Traffic Engineer's Statement

Jeffrey R. Planck, P.E., PE #53006

August 13, 2021
Date

CROSSROADS AT MEADOWBROOK-MIXED USE PRELIMINARY PLAN

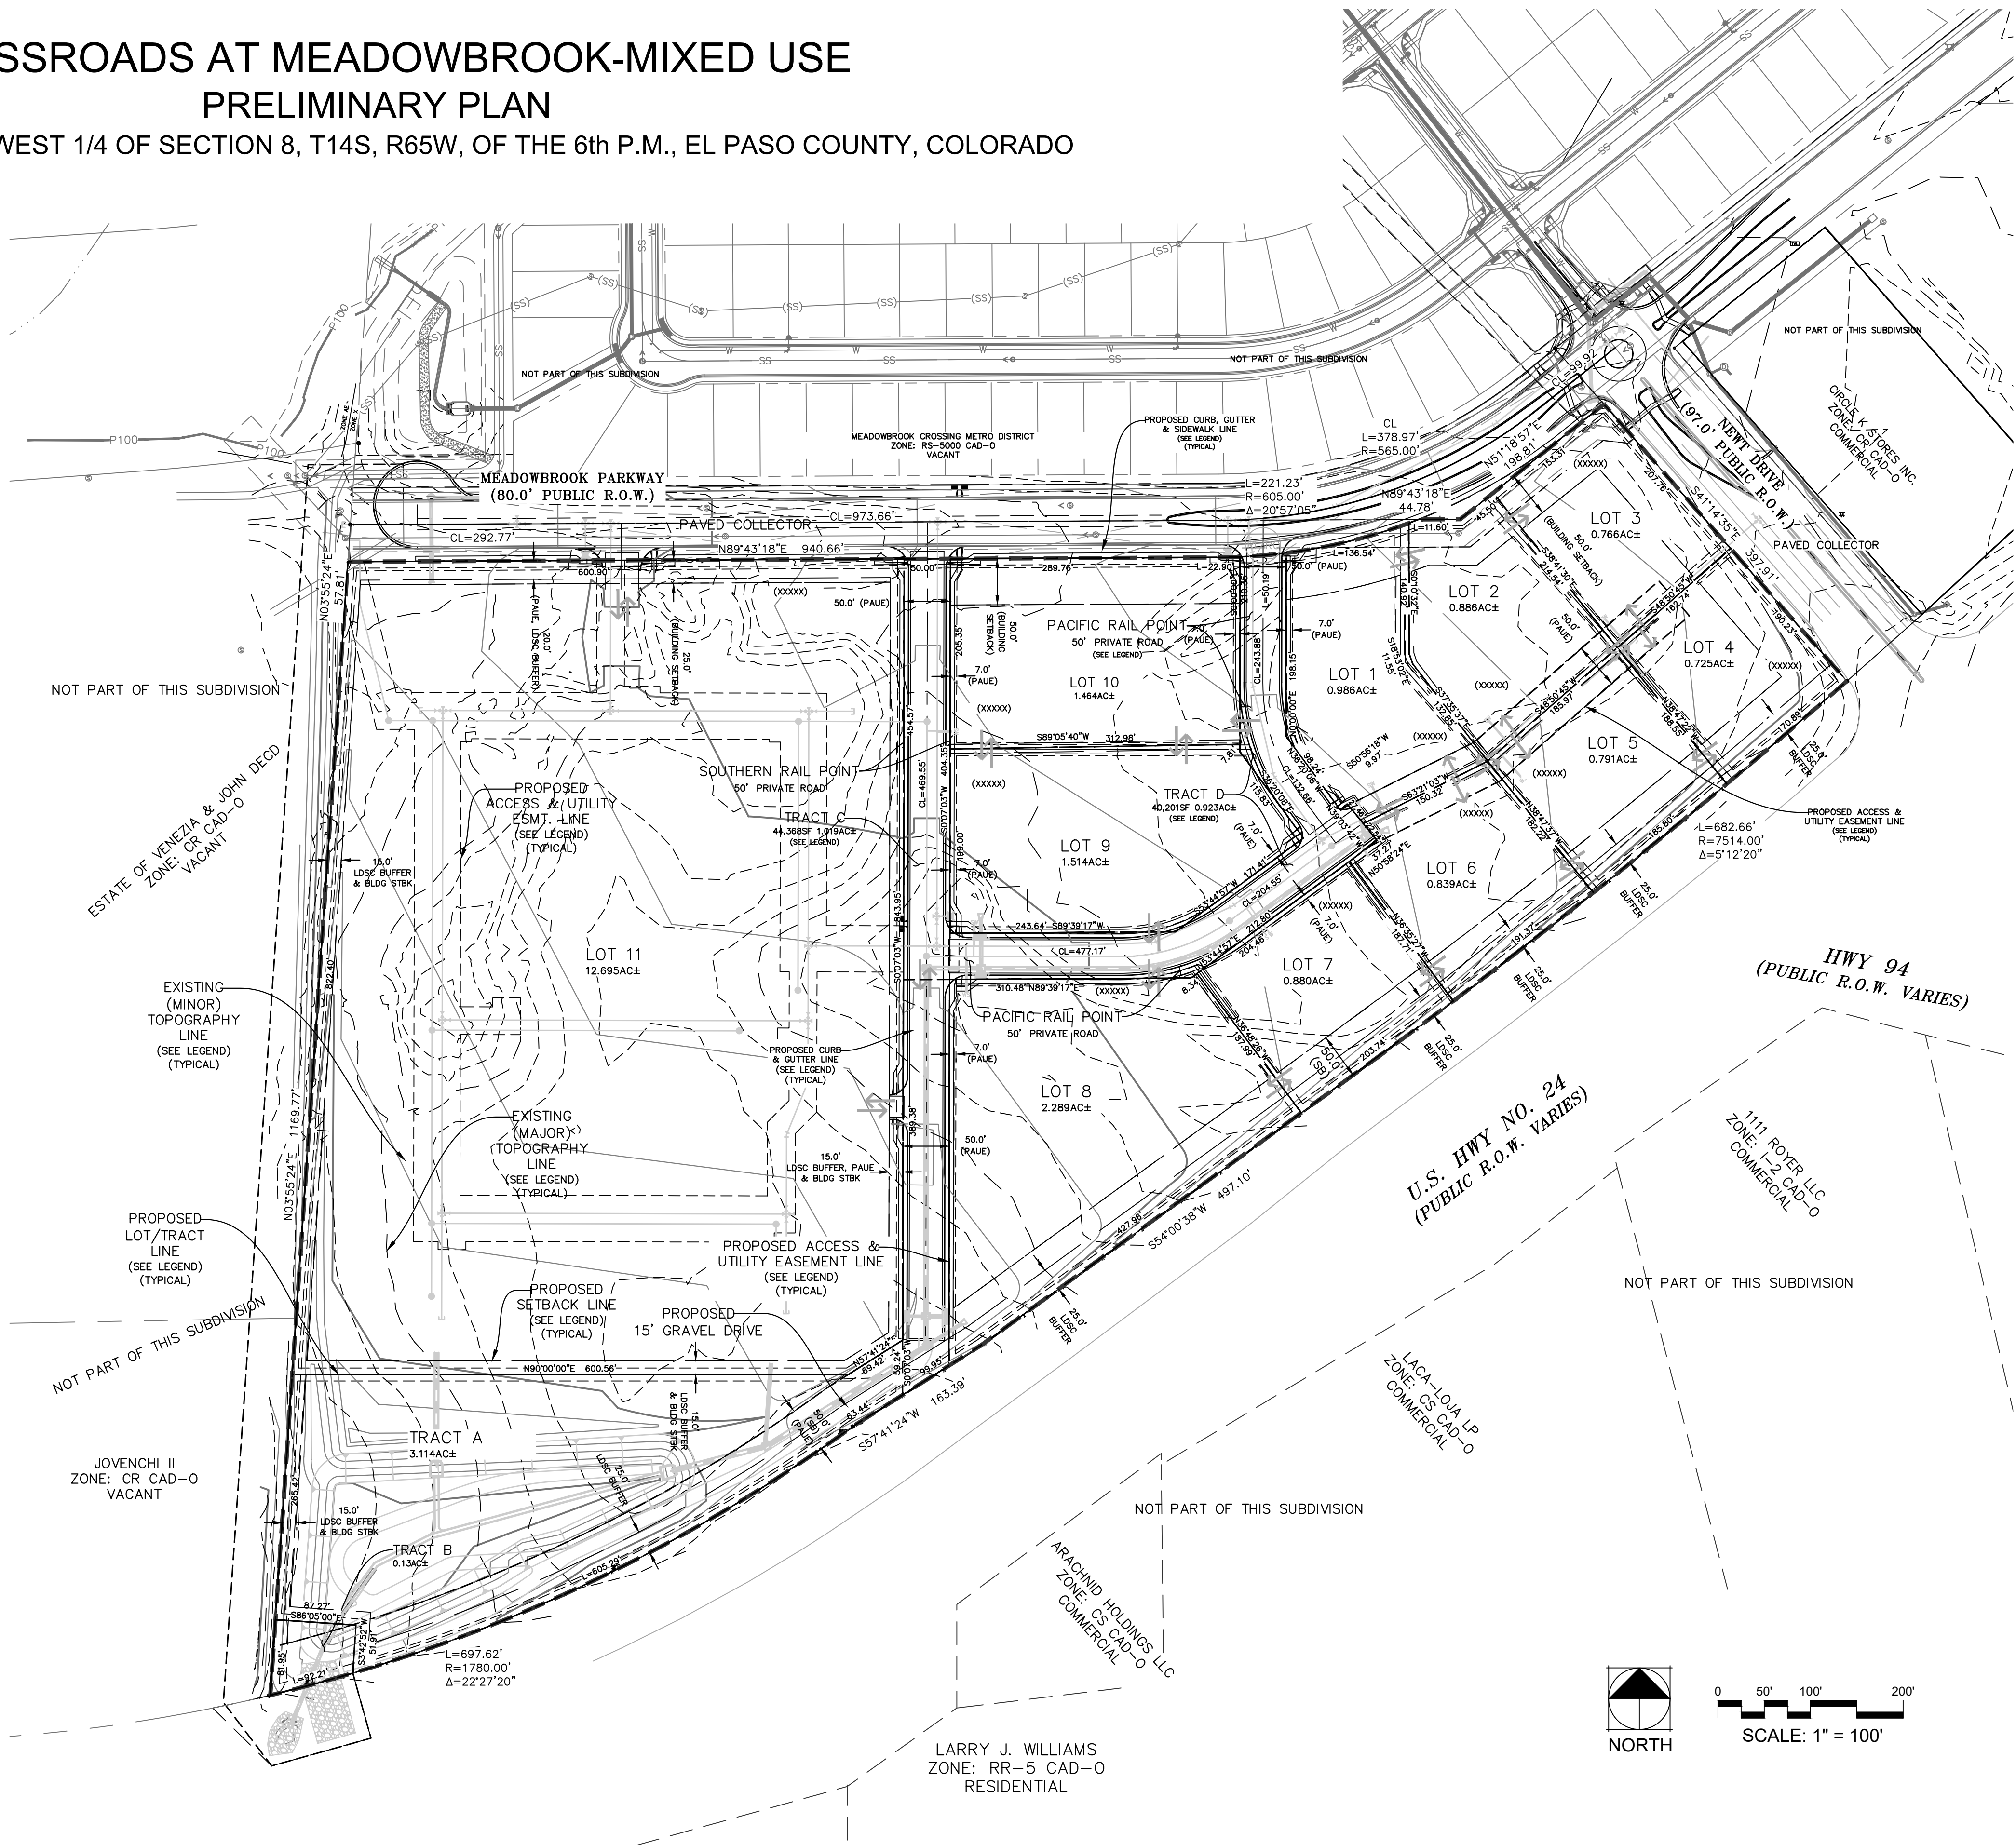
Per criteria this warrants exclusive left and right turn lanes. Revise the preliminary plan street layout to allow restriping for a second outgoing lane or submit deviation request for consideration.

Unresolved. A deviation request was not included with the 4th submittal. In reviewing the private road there appears to be room to reconfigure the cross section to fit the two separate turn lanes on the 36' pavement width (3x 12' lanes). If you rescind the deviation request, then update the TIS narrative by identifying the phasing for the left turn lane. Include the following:

- 1. Identify in the short range horizon lane configuration such as either to a) chevron stripe the left turn lane or b) stripe per the standard cross section provided. (Add the cross section in the preliminary plan if you are going with "a")**
- 2. Identify the long range horizon lane configuration to include how long this separate lane should be (provide the cross section in the preliminary plan).**
- 3. Identify the trigger/warrant for installing the separate left and right turn lane. Seems likely to be when Marksheffel/Peterson connection is made.**
- 4. Identify who will be responsible to restripe the entrance once it's warranted.**

The project team will include separate northbound left and right turn lanes at the middle access along Meadowbrook Parkway and will not pursue a deviation request. We agree that one receiving lane, a separate left turn lane, and a separate right turn lane can be accommodated within the 36 feet of pavement width. The following are responses to the comments for left turn phasing:

- 1) The project will include in the northbound left turn lane at the middle access in the short-term horizon and a cross section will be included in the preliminary plan. Chevron striping will not be provided in the short-term as restriping a left turn lane in the future is not desired.

- 2) The storage length required at this northbound left turn lane in the short term is only 50 feet shorter than the storage length required for the long-term horizon; therefore, the long-term configuration is recommended for the short-term horizon to avoid restriping this lane again in the future. As such, the short and long-term configuration for the northbound left turn lane at the middle access is 115 feet of lane length plus 100 feet of storage plus a 120-foot taper.

- 3) The trigger for the northbound left turn lane at the middle access would be when Meadowbrook Parkway is extended to Peterson Road; however, the northbound left turn lane will be implemented in the short-term.

- 4) The project will incorporate the northbound left turn lane with the initial phase of development.
